June 23, 2017

AOA-5327

**SUBJECT: Response to ESA Peer Review Comments for Platau Residence
8316 Avalon Drive, Mercer Island, WA (Parcel 032110-0290)
City #CAO17-002**

STREAM BUFFER MITIGATION PLAN
EXISTING CONDITIONS
PLATOU RESIDENCE
8316 AVALON DR.
MERCER ISLAND, WA 98040

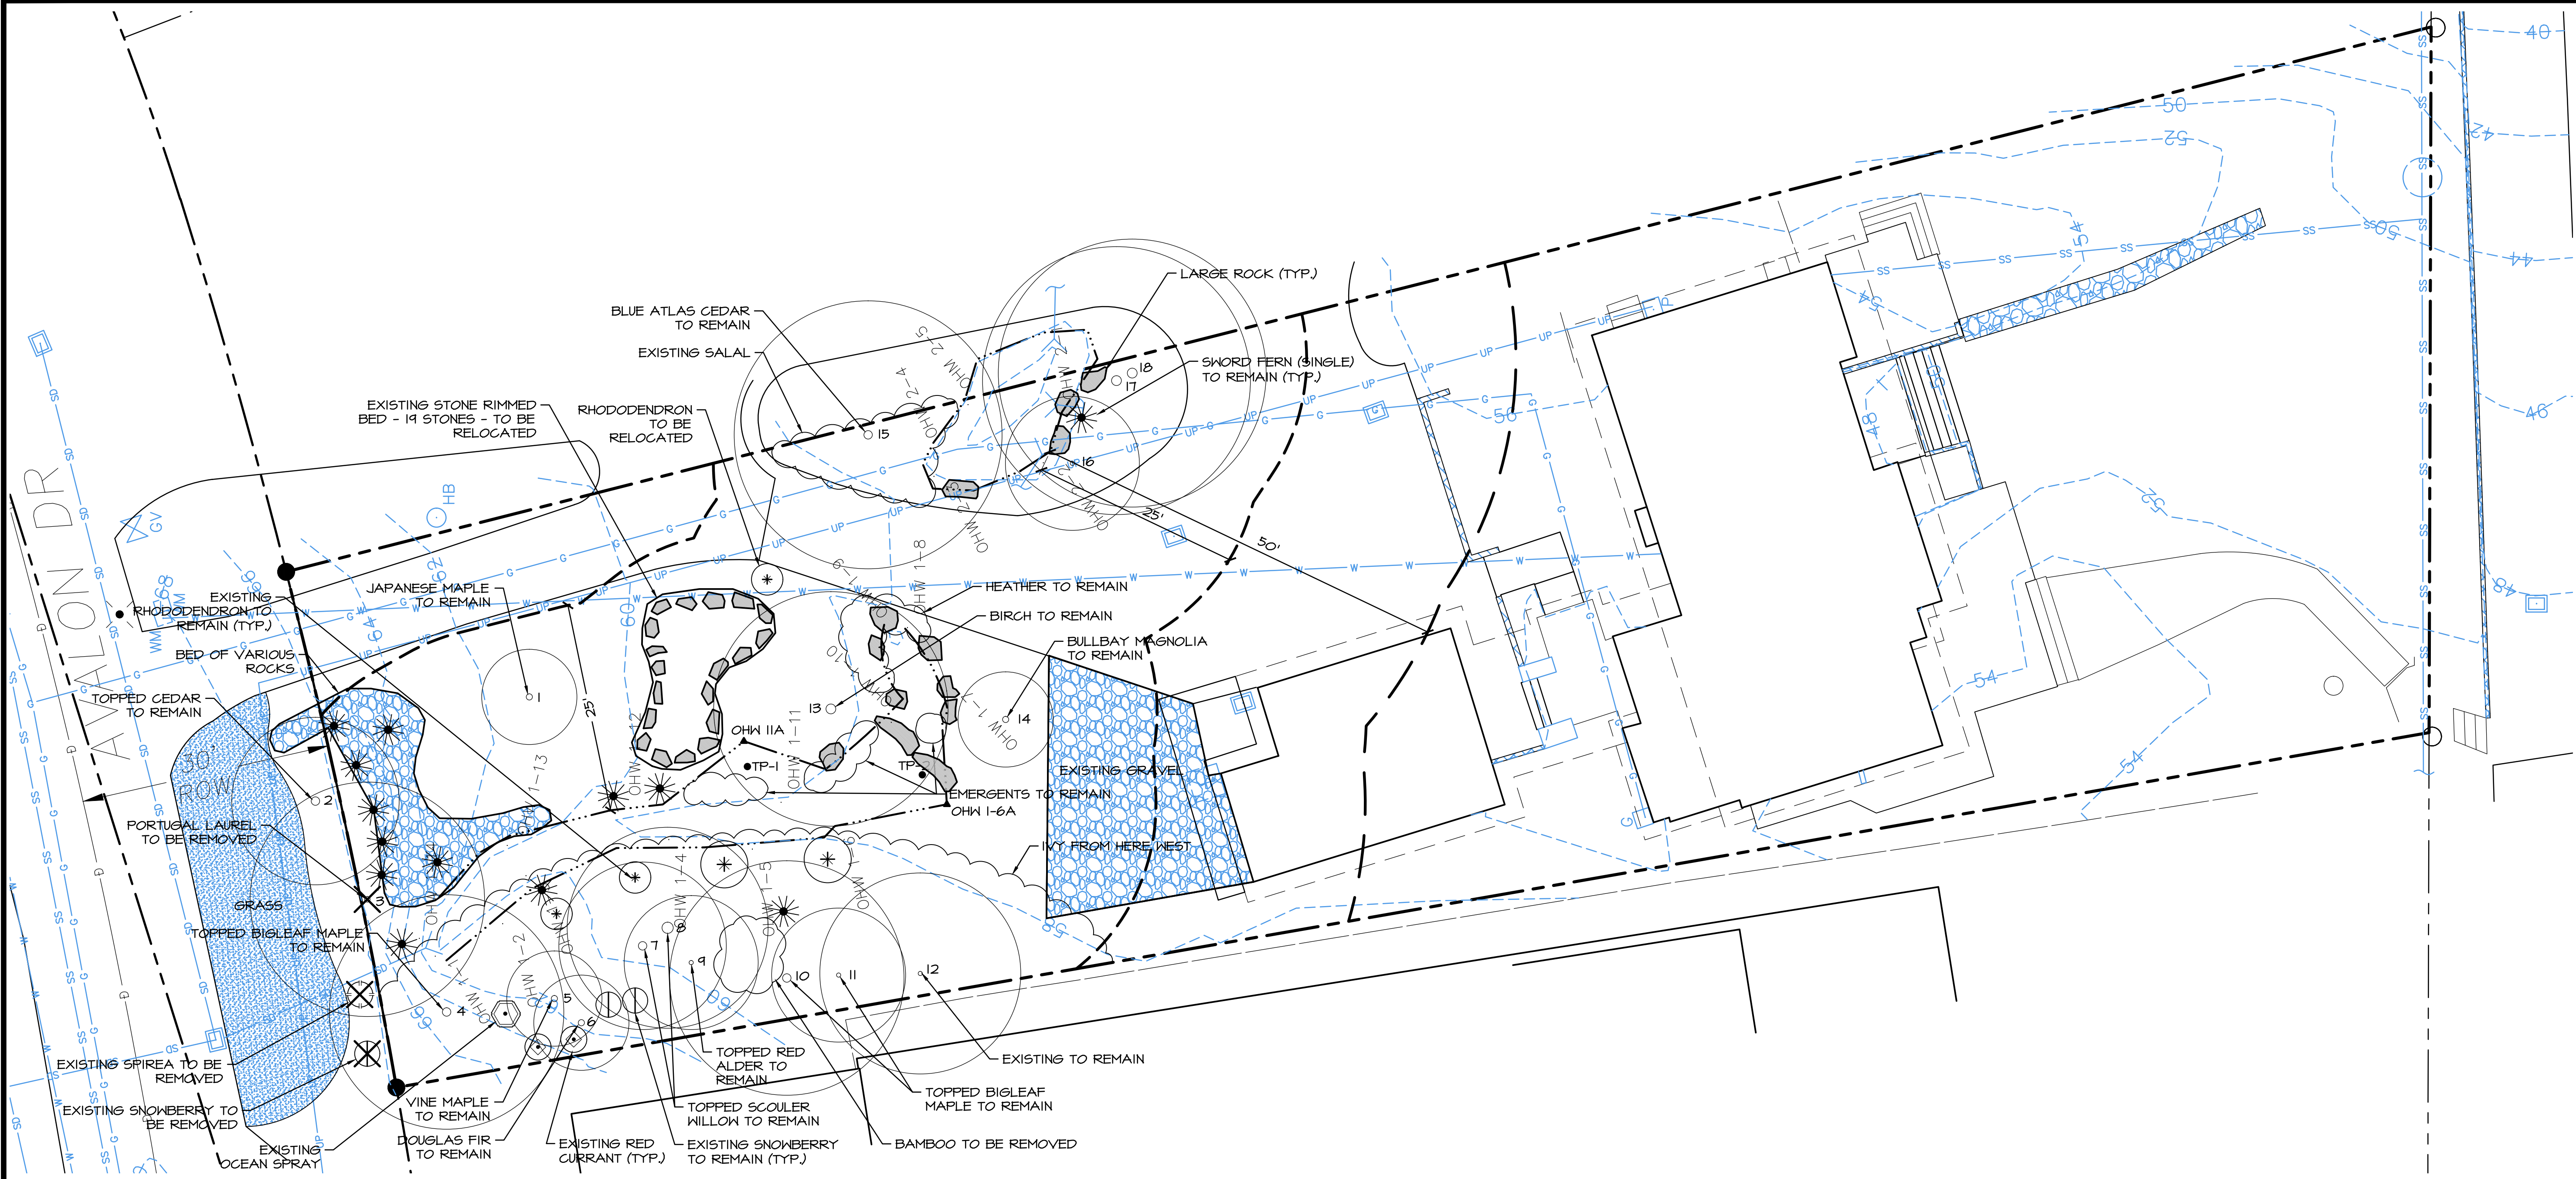
- *Based on our observations of site conditions, we recommend that two relatively small areas adjacent to the on-site stream be further investigated for wetland indicators, with documentation provided in an updated CAS. Based on this investigation, if any wetland area is identified or the stream OHWM is expanded, we recommend that project materials be updated to reflect conditions and associated MICC Chapter 19.07 requirements.*

- *We recommend that an arborist report be developed, as required when removing large trees from a critical tree area.*

The 2 small areas adjacent the stream identified by ESA were re-evaluated and the plans were revised to include the areas within the OHW of the stream. Attachment A of the revised critical areas study includes data plots at the 2 locations and Section 1.1 has been added to the report.

The only tree now proposed for removal is an invasive Portugal laurel located along the north property line.

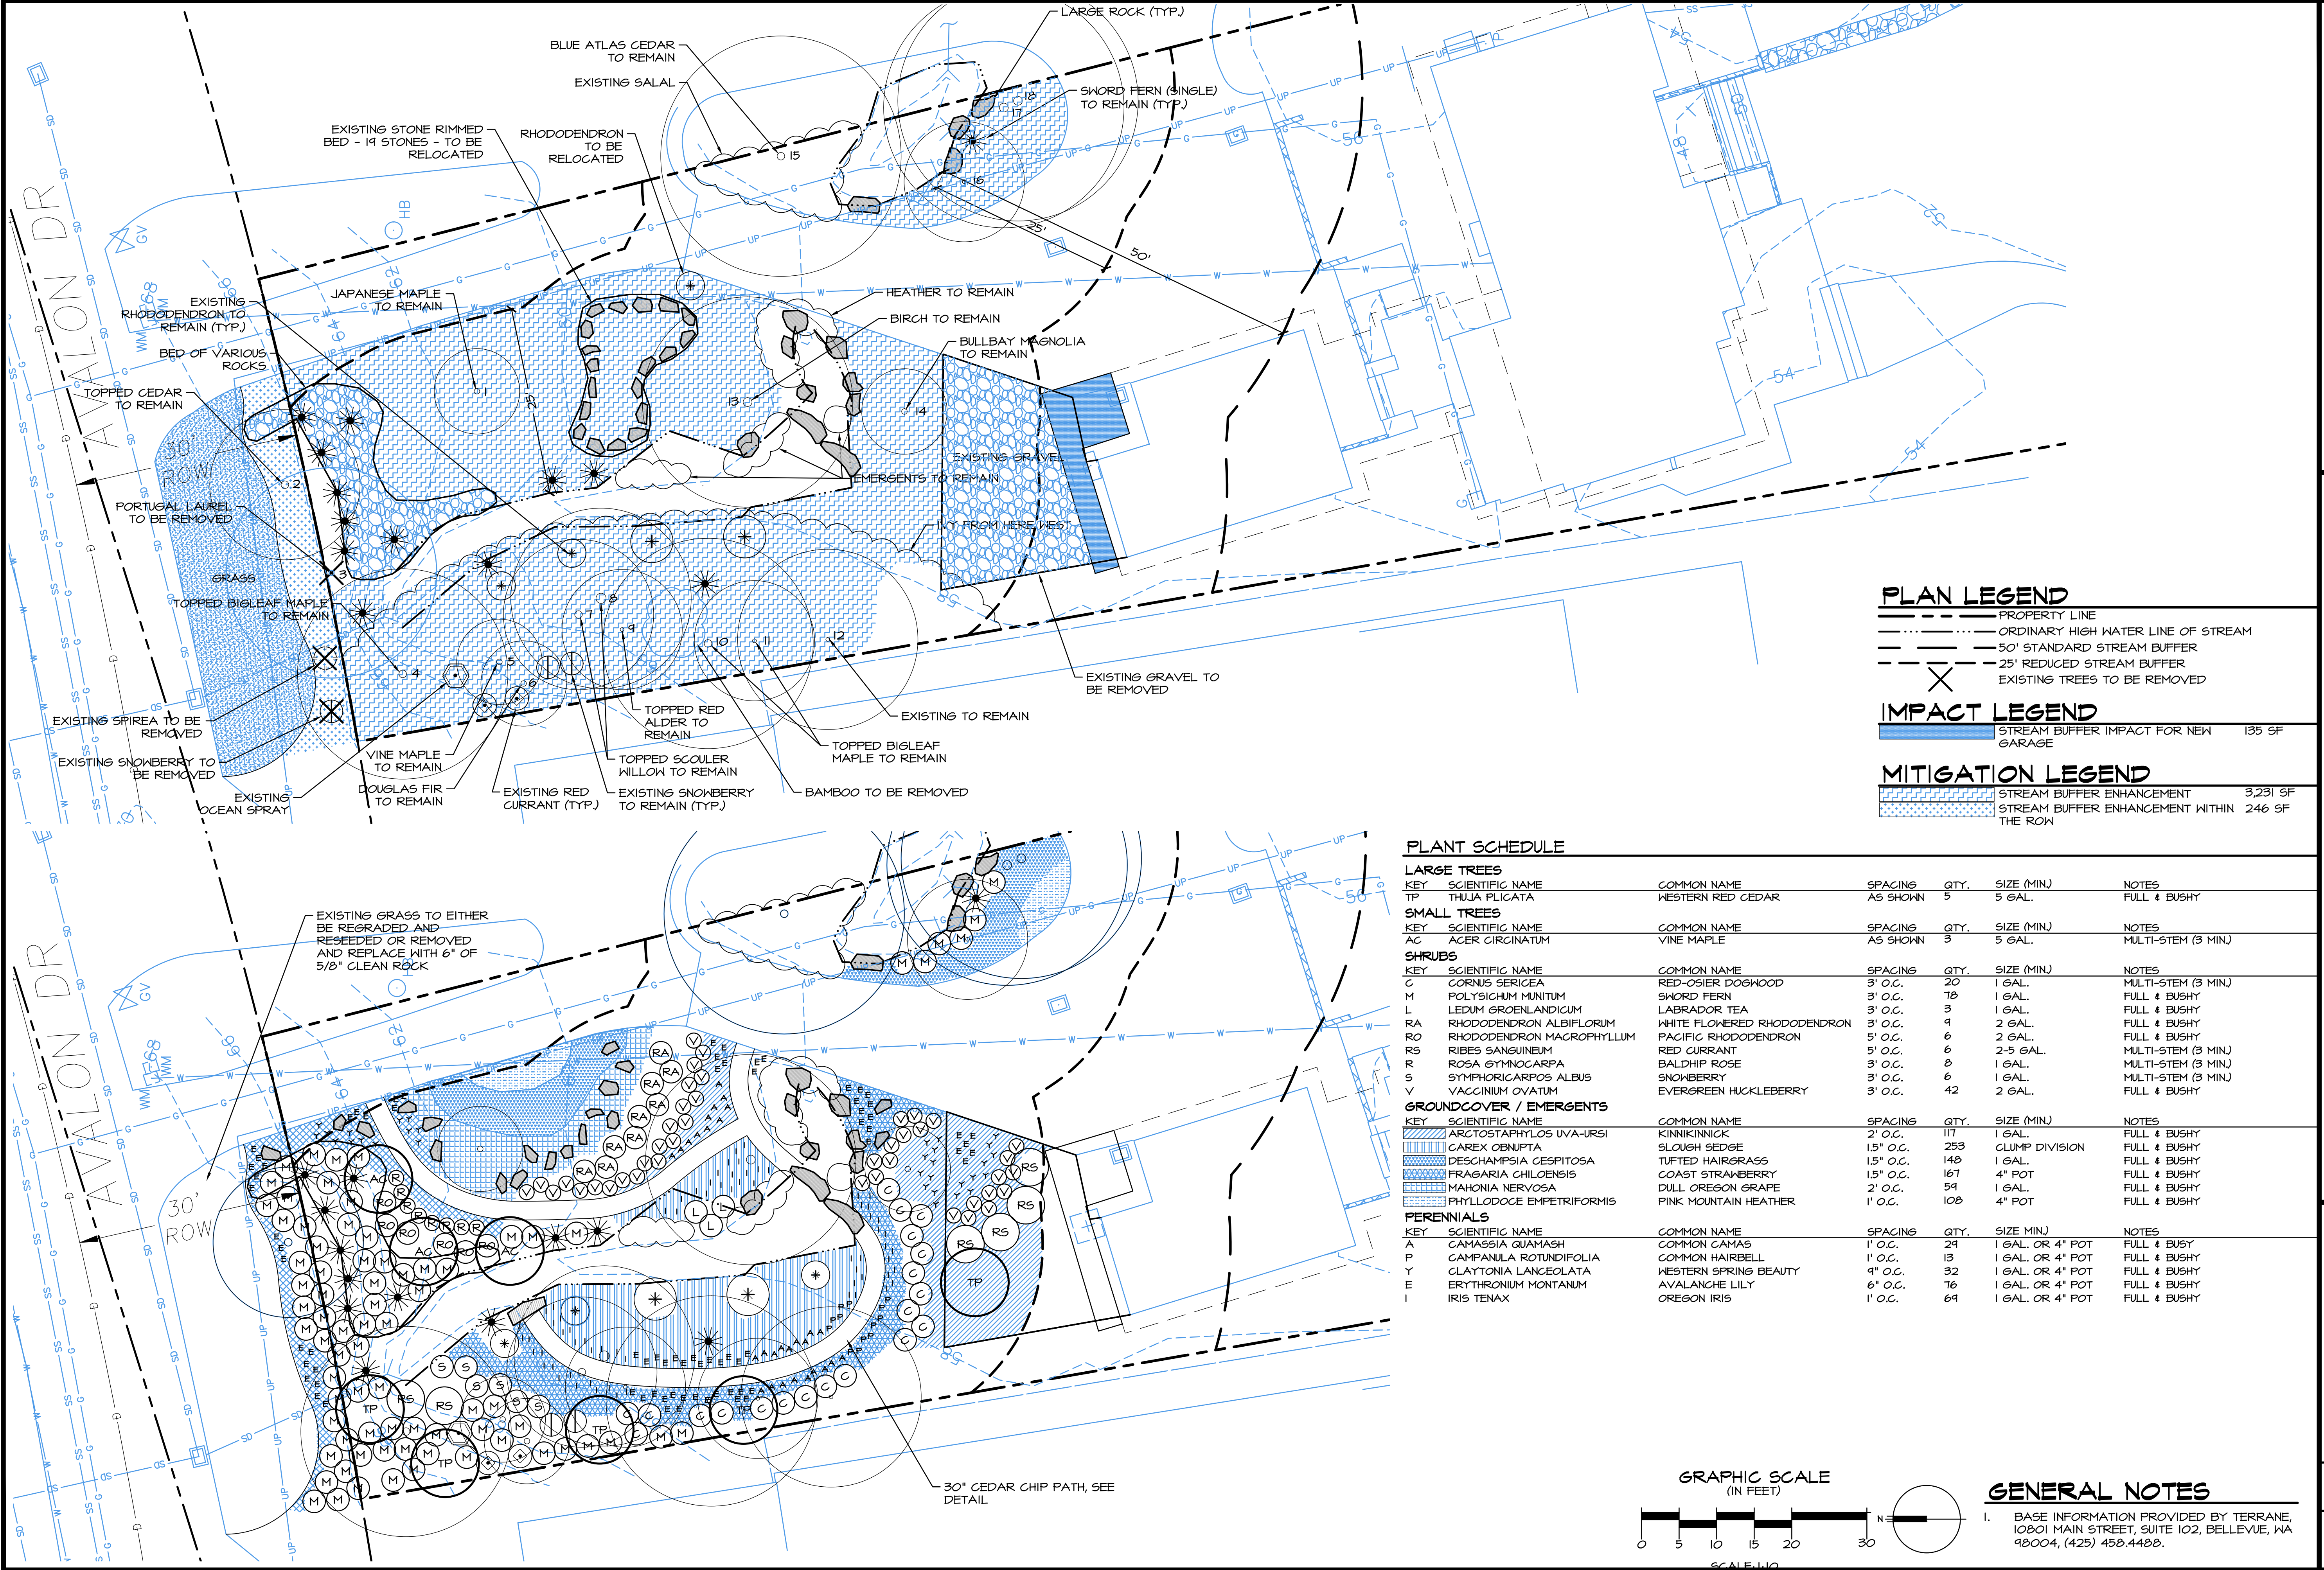
- *In addition to proposed invasive species removal and buffer enhancement within the reduced buffer area, we recommend that the City require removal of the gravel parking area that would be within the 25-foot reduced buffer. This area should be incorporated into the buffer mitigation plan, including restoration of underlying soils and planting with native species. Removing the impervious surface within the 25-foot buffer combined with removing invasive species and replanting with native species is appropriate mitigation for the proposed buffer reduction.*

- *We recommend increasing the spacing of the western red cedars (*Thuja plicata*) to at least 15 feet apart to give them room to grow.*

- *On the planting plan, sword fern (*Polystichum munitum*) does not have a corresponding letter in the plant schedule. Confirm if "M" corresponds to sword fern and revise the plant schedule accordingly.*

- *If wetland areas are identified on the site (or the OHWM is expanded to include wetter areas along the stream corridor), soil and hydrology conditions should be taken into account for plants selected for these areas. For the areas noted on Figure 1, we recommend the following plant changes to species more appropriate for wet conditions:*
 - *Substitute sword fern with Labrador tea (*Ledum groenlandicum*)*
 - *Substitute coast strawberry (*Fragaria chiloensis*) with bunchberry (*Cornus canadensis*)*
 - *Substitute common camas (*Camassia quamash*) with western columbine (*Aquilegia formosa*)*

The proposed mitigation plan has been revised to depict removal and restoration of the gravel parking area located within 25 feet of the OHW of the stream.

The spacing of the cedars has been increased on the plan.

The plant schedule for sword fern has been revised accordingly.

The planting plan has been revised accordingly.
